**Ecological comments**

**Planning Application No:** 03/2013/0357

**Proposals:** Proposed erection of a 60.7m single wind turbine and associated sub-station, concrete pad and access track

**Location:** Land to the North of Huntroyde Home Farm, Huntroyde West, Whins Lane, Simonstone, BB12 7QL

Figure 1 Site location.

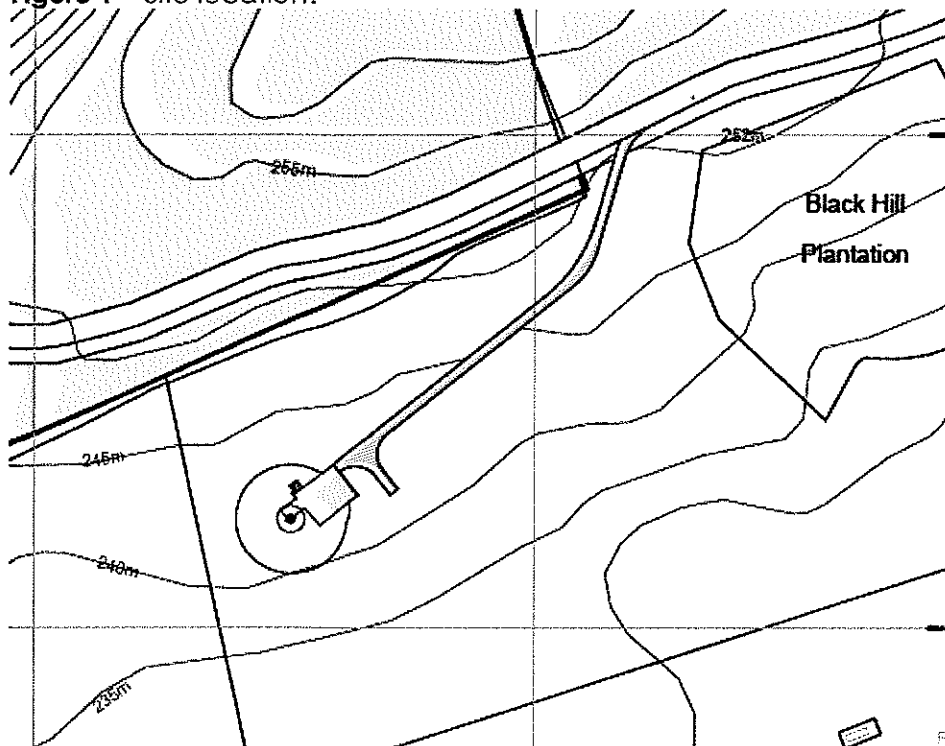
I have reviewed the following ecological information submitted in support of the application: *Ecological Scoping Assessment – Huntroyde Home Farm* (Brooks Ecological, February 2013) and *Bat Survey and Assessment – Huntroyde Home Farm* (Brooks Ecological, February 2013). Unfortunately the bat survey relates to a site approximately 350m north of the proposed turbine.

Natural England endorses the BCT guidance (2012) through their standing advice. The BCT guidelines also set out the minimum standards for bat surveys at proposed turbine developments. This indicates that some level of bat survey would be appropriate, even in low risk sites. Although a bat report has been submitted, it is not for the current location of the turbine. In any case, the surveys that were undertaken do not appear to be in accordance with the BCT guidance (2012) e.g. amount of survey undertaken.

On the basis that high bat activity and high risk species (noctule) have been recorded in the area, it is my opinion that bat surveys are required to ascertain whether the 56m distance of the turbine would be appropriate in this particular location and to inform the need for additional/amended mitigation proposals. In the absence of surveys it is not clear that the turbine would not result in offences (e.g. killing and injuring of bats / significant impacts on bat populations locally).
